**CITY OF PORTLAND, MAINE  
DEVELOPMENT REVIEW APPLICATION  
PLANNING DEPARTMENT PROCESSING FORM  
DRC Copy**

**2003-0236**

**153 Hope Ave (lot#23)**

**Approval Conditions of DRC**

SITE PLAN
 LOT 23, PRESUMPSCOT RIVER PLACE, PHASE III
 HOPE AVE, PORTLAND, ME
 1" = 20'

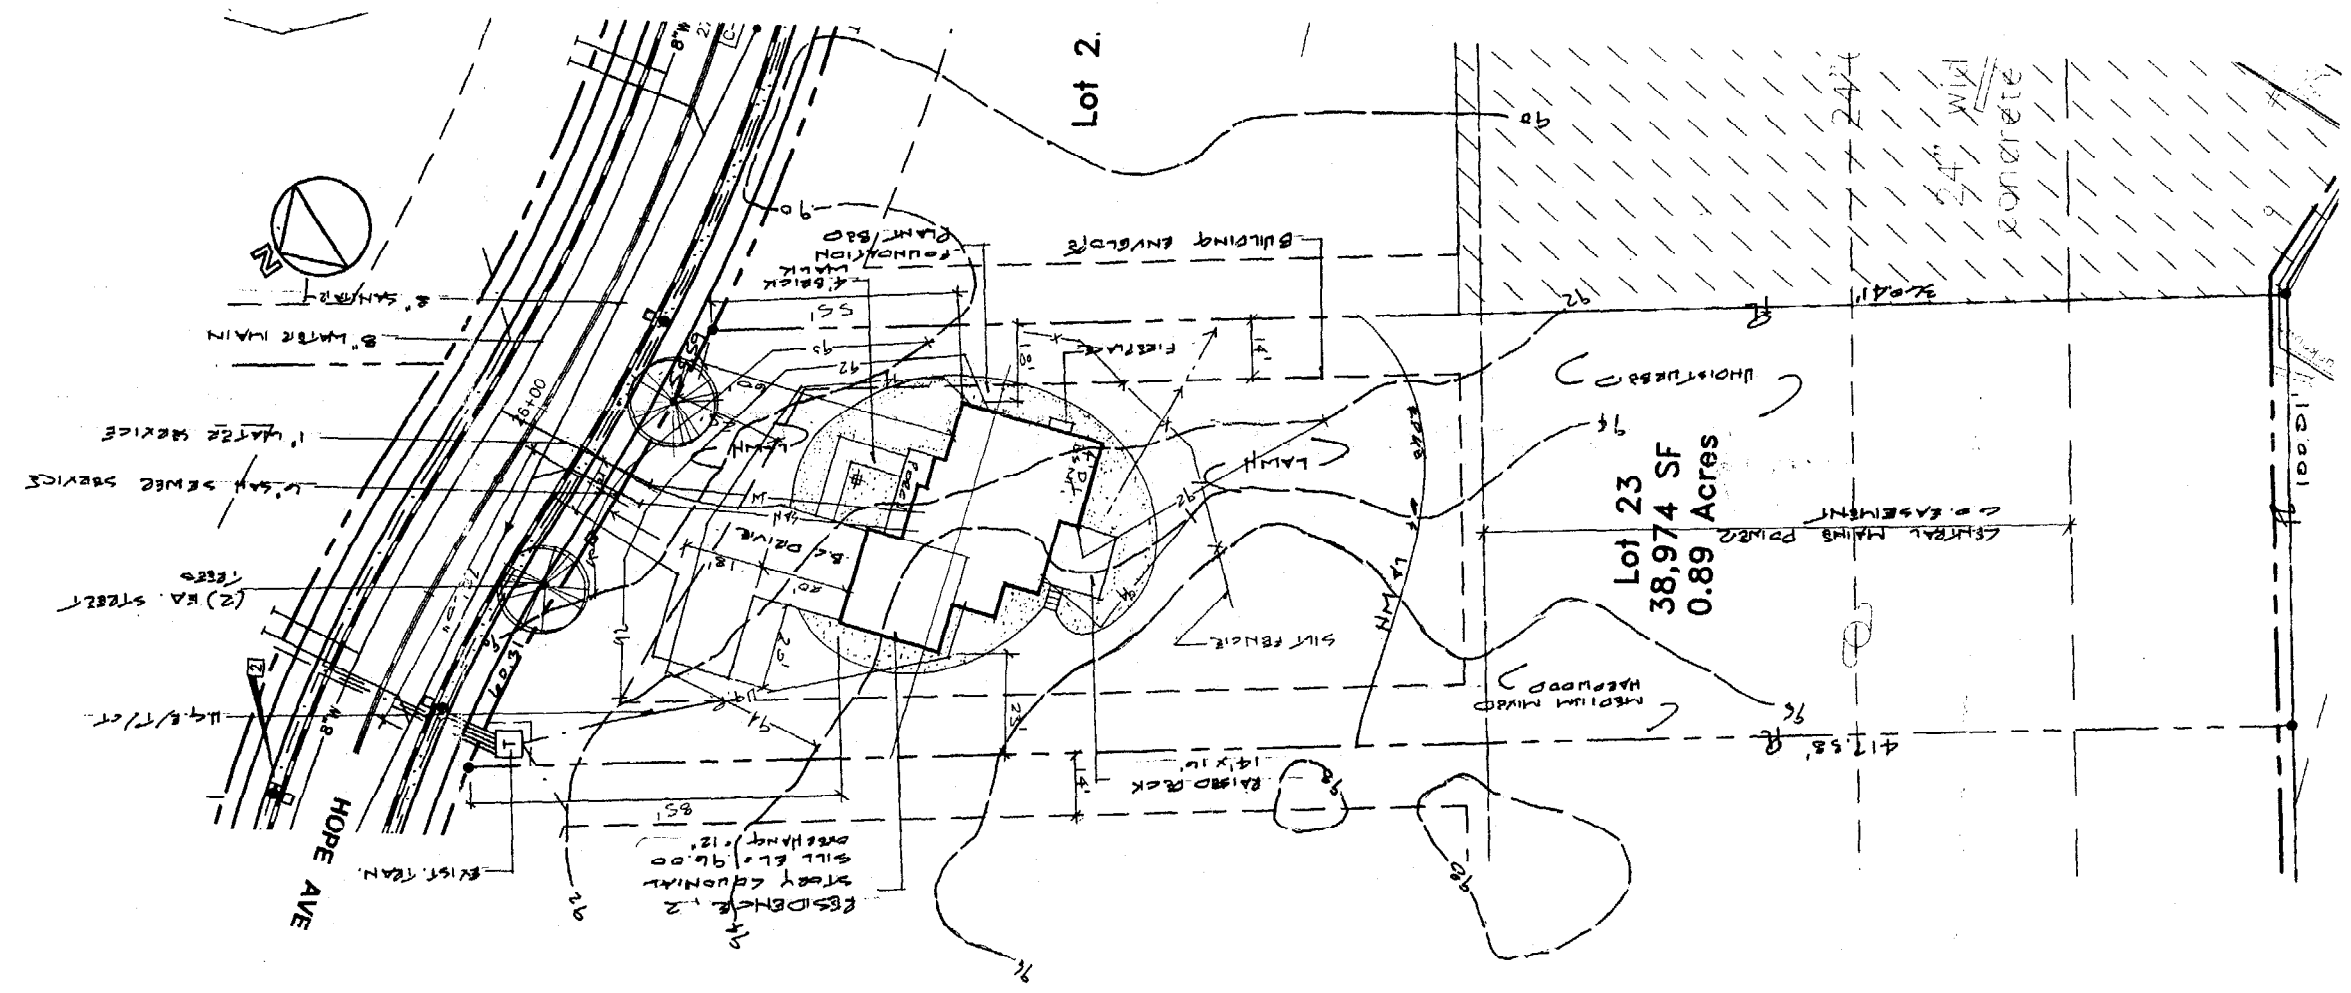
- 1 APPLICANT TO COORDINATE WITH NEIGHBOR (LOT 22) TO LOCATE DITCH/FINAL GRADING ALONG SHARED PROPERTY LINE.
- 2 Two (2) City of Portland approved species and size trees must be planted on your street frontage prior to issuance of a Certificate of Occupancy.
